Job ID No.: A816319; A830502
File number: 11/04059
Your ref: SSD 5036-2011

Re: Exhibition of Environmental Impact Statement for New Comprehensive Cancer Care and Blood Disorder Centre at Prince of Wales Hospital – (SSD 5036-2011)

Vincent Sicari
Manager, Conservation Team
Heritage Branch
Office of Environment and Heritage
Department of Premier & Cabinet
AS DELEGATE OF THE NSW HERITAGE COUNCIL

1
SECTION 01
1:100

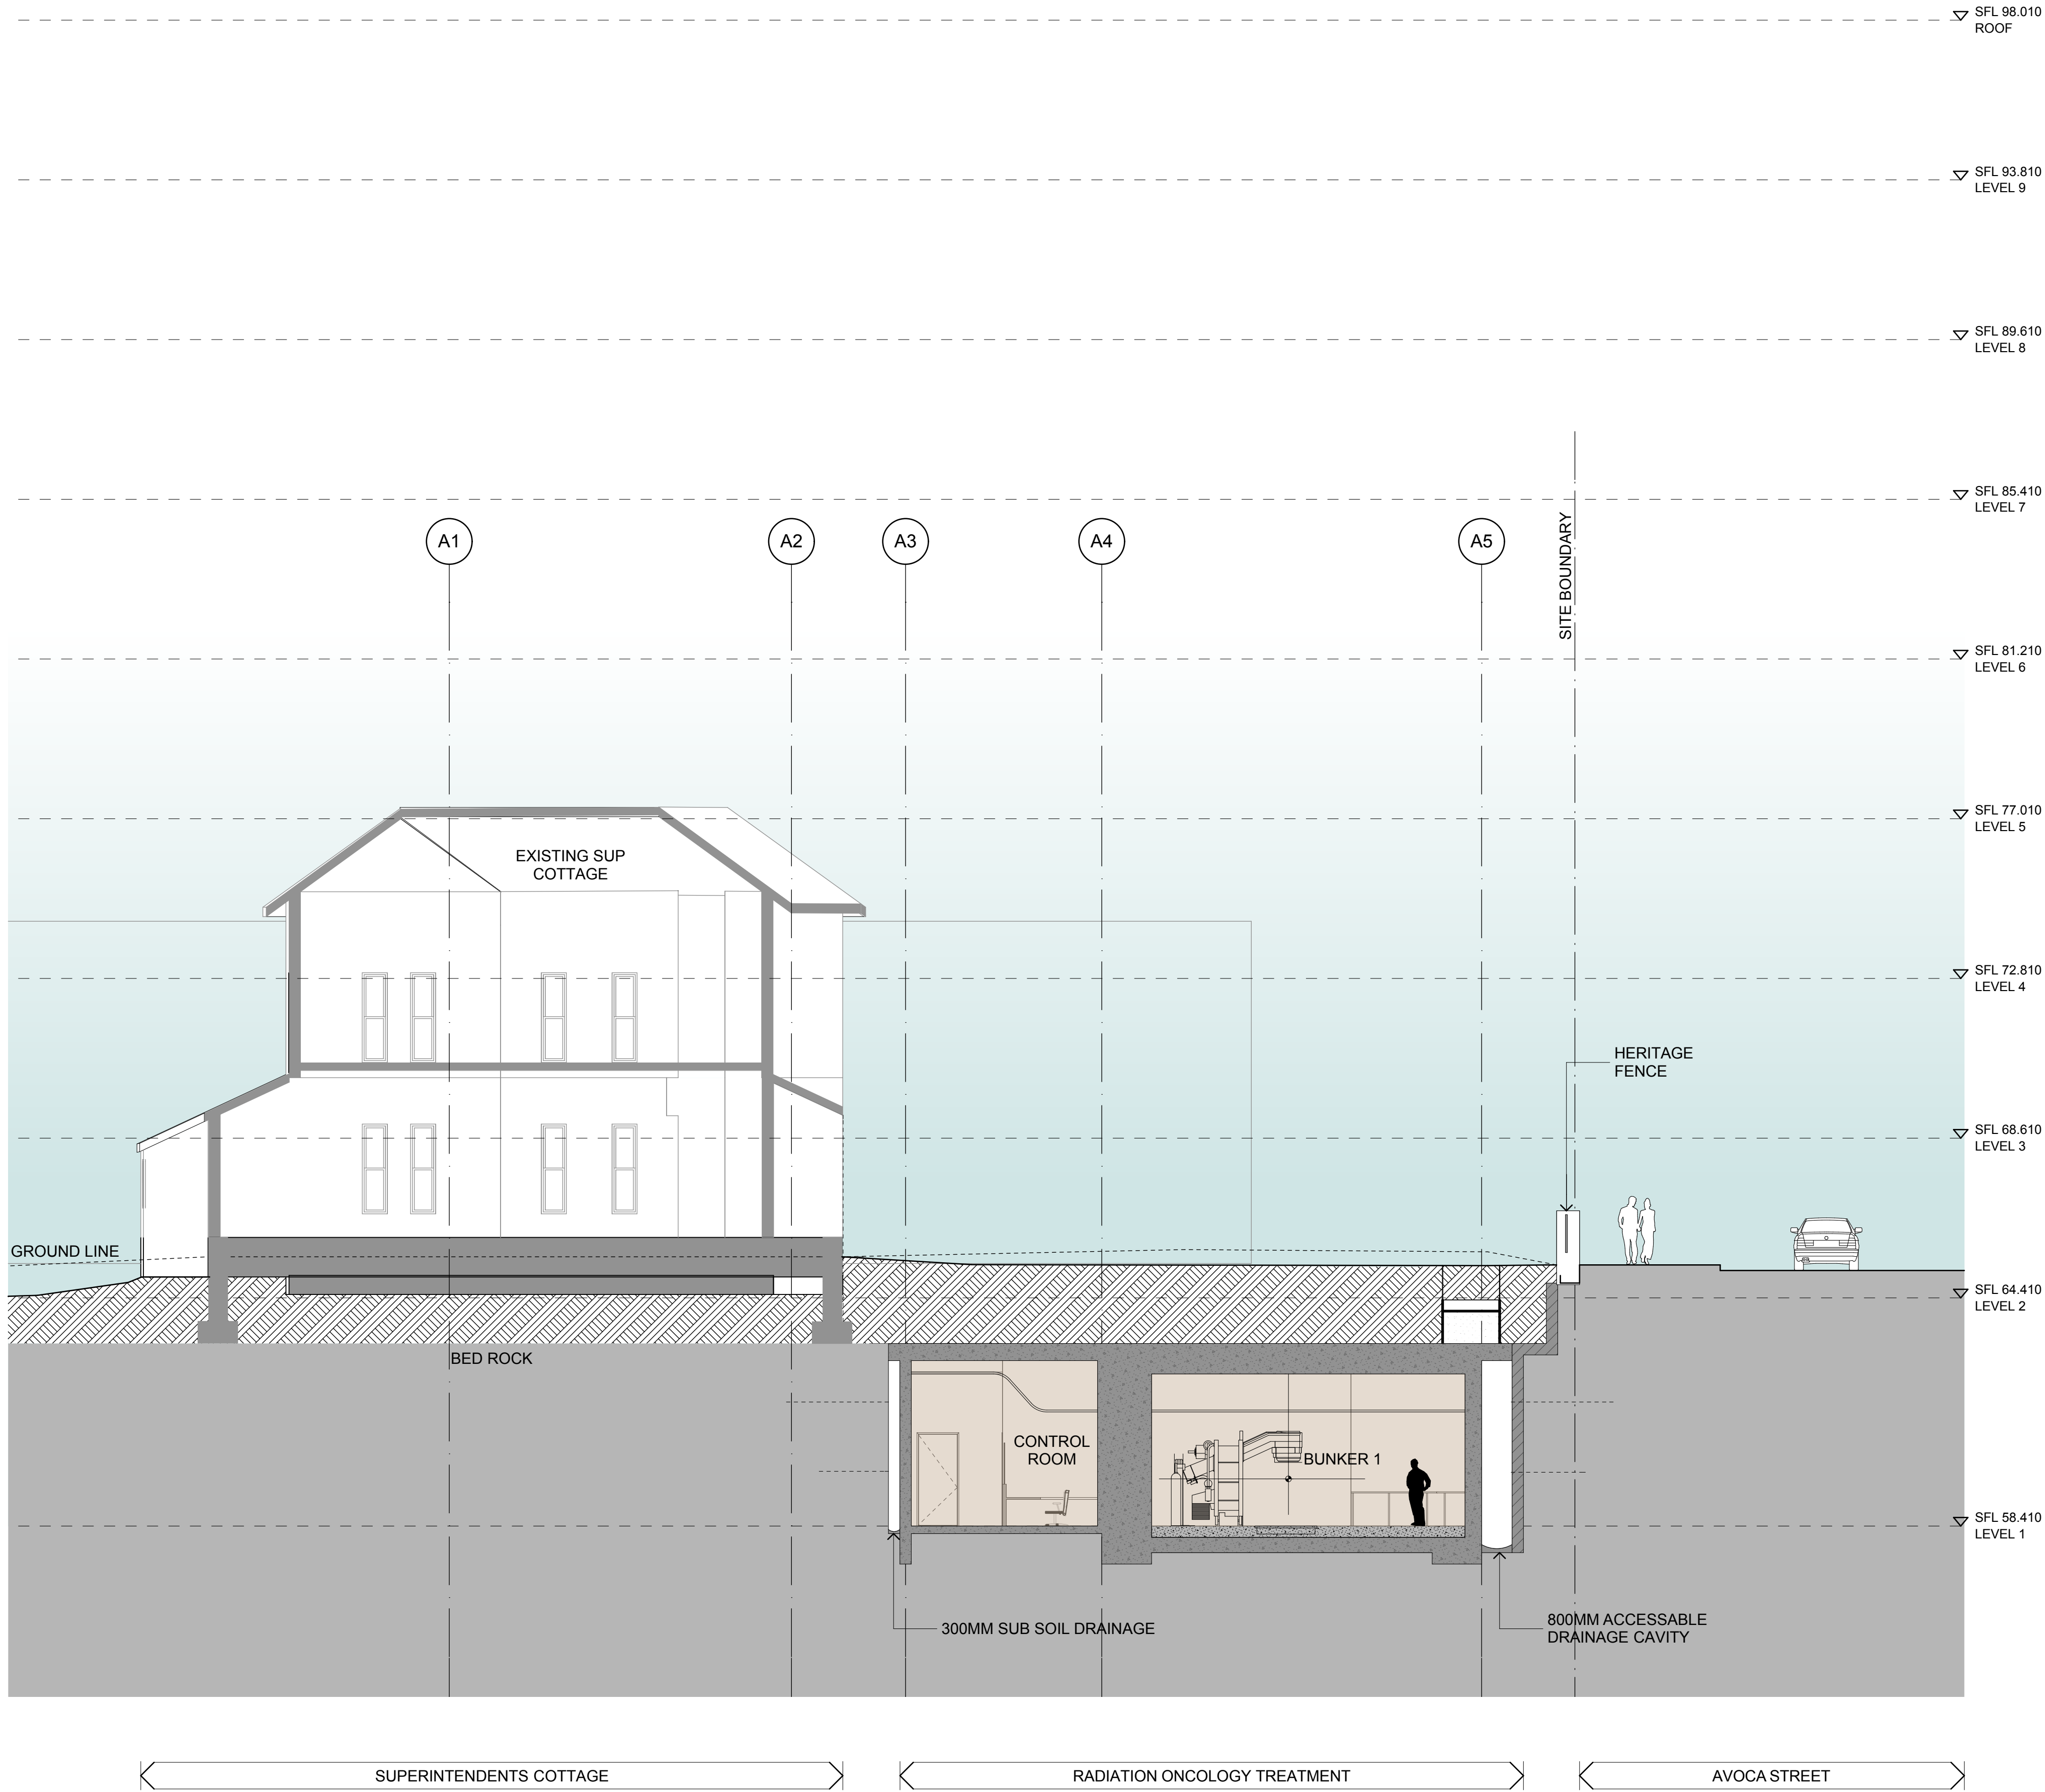
During the meeting held on 1 May 2012, however, the Heritage Branch noted that Section 01 as shown on Drawing Number 11507 SD1601 Issue C indicates that the excavations for the new bunkers might potentially disturb the footings of the Superintendent's Residence subject to the nature of the underlying rock which is to be excavated for the bunkers. It is noted that the civil and structural engineering

report has considered excavation of the rock and in particular the excavation adjacent to boundaries and Heritage buildings. The advice is that the rock will typically stand vertically without support and that excavated faces should be investigated at the time of excavation to assess if localised dowelling is required to control adversely orientated jointing within the face of the rock and to identify areas that may require protection by shotcrete. The existing report, however, also advises that: *'the excavation perimeter around heritage buildings should be sawcut and allows for the excavation to be taken very close to the existing heritage walls, provided that the footings of these buildings are bearing on adequate material. This will be confirmed during excavation and some local underpinning of the footings may be required. Additional excavation works including trial pits have been requested...'* (page 11).

1. The Construction Management Plan is to address the impacts of the excavation for the new bunkers in the vicinity of the Heritage buildings and the Superintendent's Residence in particular, to ensure that proposed excavation methods are appropriate to protect the building(s) from damage.

2. Additional structural engineering advice and assessment must be obtained regarding the adequacy of the proposed set-back in the vicinity of the Superintendent's Residence and specific measures to mitigate construction impacts on the building once the underlying character of the sub-surface material in this area is known.

3. A comprehensive Condition Report should be undertaken for the Superintendent's Residence prior to the commencement of any excavation work for the new bunkers. That report should form the basis for assessment of any impacts arising from the work and for any future remedial works which may be required.
